East Anglia ONE North (EA1N)  
East Anglia TWO (EA2)  
Offshore Wind Farms  
[Planning Inspectorate References: EN010077 and EN010078]

**Post hearing submission on Issue Specific Hearing 16 (ISH16), Session 2**

Submitted for Deadline 11 (07 June 2021) by

East Anglia ONE North and East Anglia TWO
Hundred River and Statutory Designated Sites Location

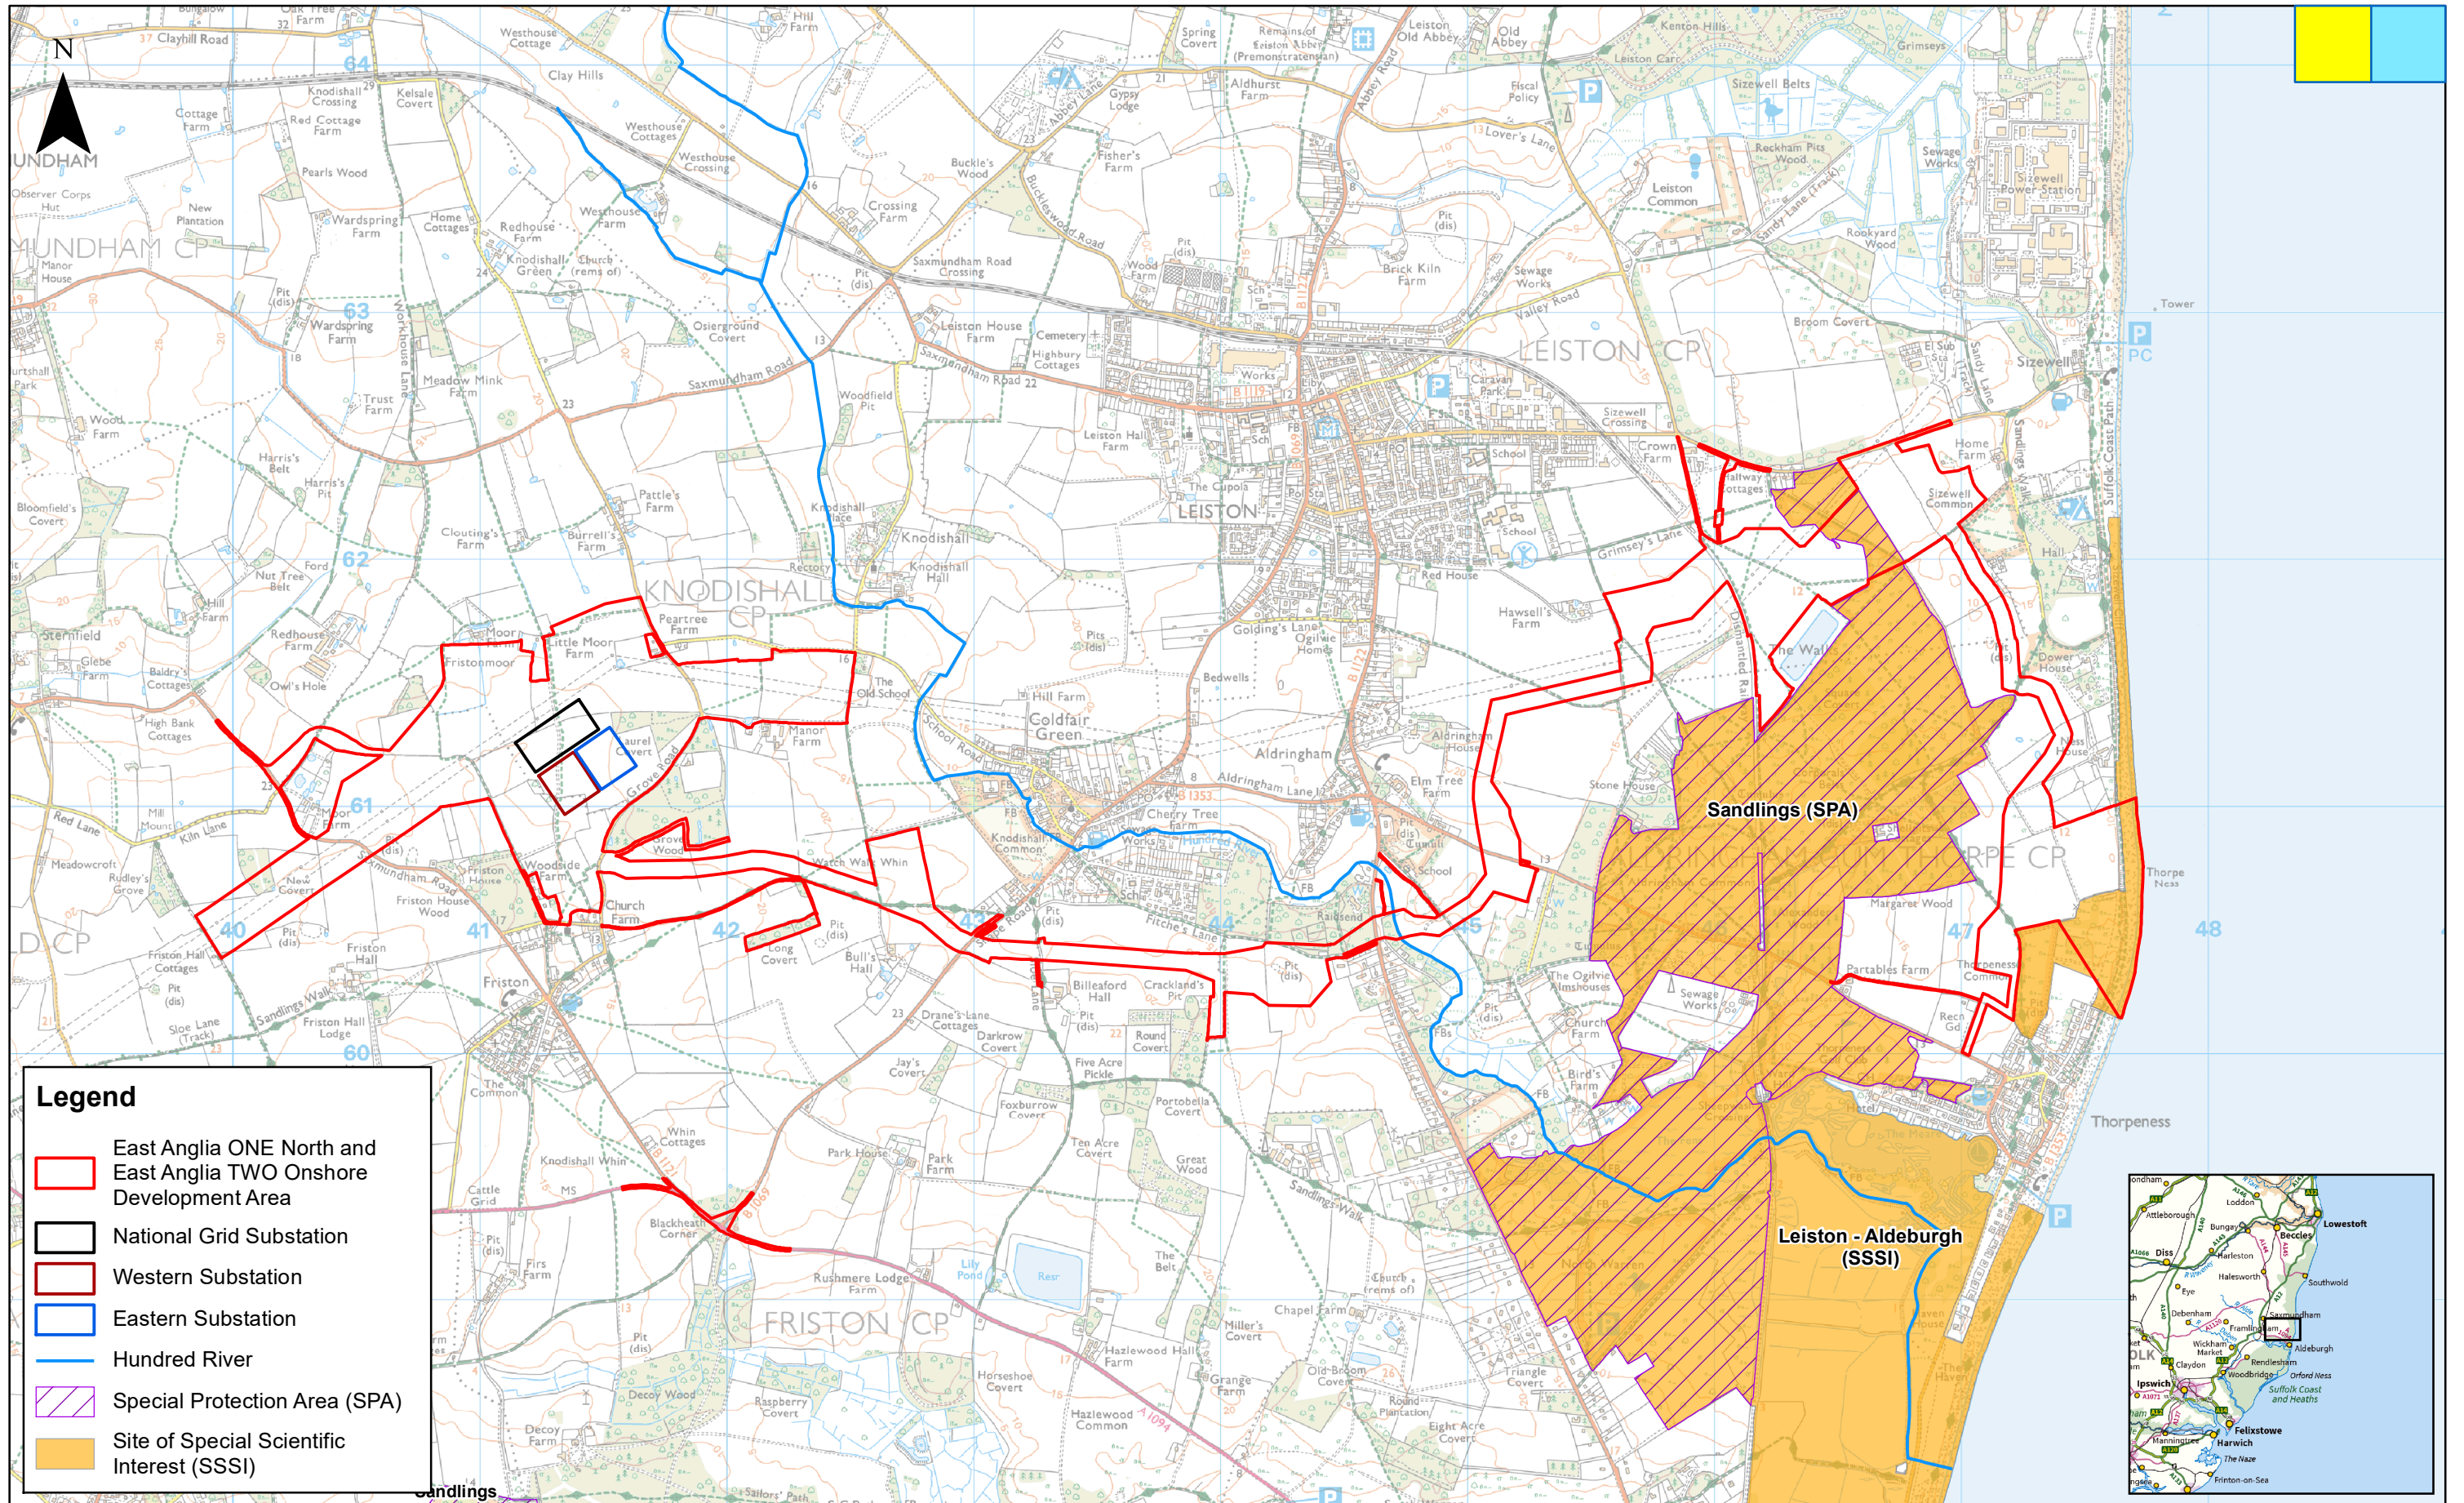
Once again the Applicants ignored the question regarding Surface Water choosing instead to refer to the Outline Watercourse Crossing Method. This document describes a proposed bypass design to redirect the river's flows during construction of open cut trenching across the Hundred River itself, but it does not address surface water flooding risks.

The Applicants did eventually respond to the question posed by ExA, referring to the specification within the Draft DCO of a widened cable corridor adjacent to east and west river banks, extending 40m both east and west of the river. On the east side beyond the 40m buffer and on higher ground this would revert to a 32 metres width.

To the west of the river beyond a 100m buffer<sup>(a)</sup>, the Applicants said that the width would be reduced to 16.1m per project and stated they would be able to use the same 40m buffer area to manage excess surface water if necessary. <sup>(a)</sup>We suspect the Applicant mis-spoke and should have referred again to a '40m buffer'.

ExA has requested at ISH16 an Outline Plan of Surface Water Management Measures for an example section of the cable corridor in order to reassure the Local Authorities that there would be sufficient room for 'worst case' Surface Water Management within the constrained lengths of the cable route.
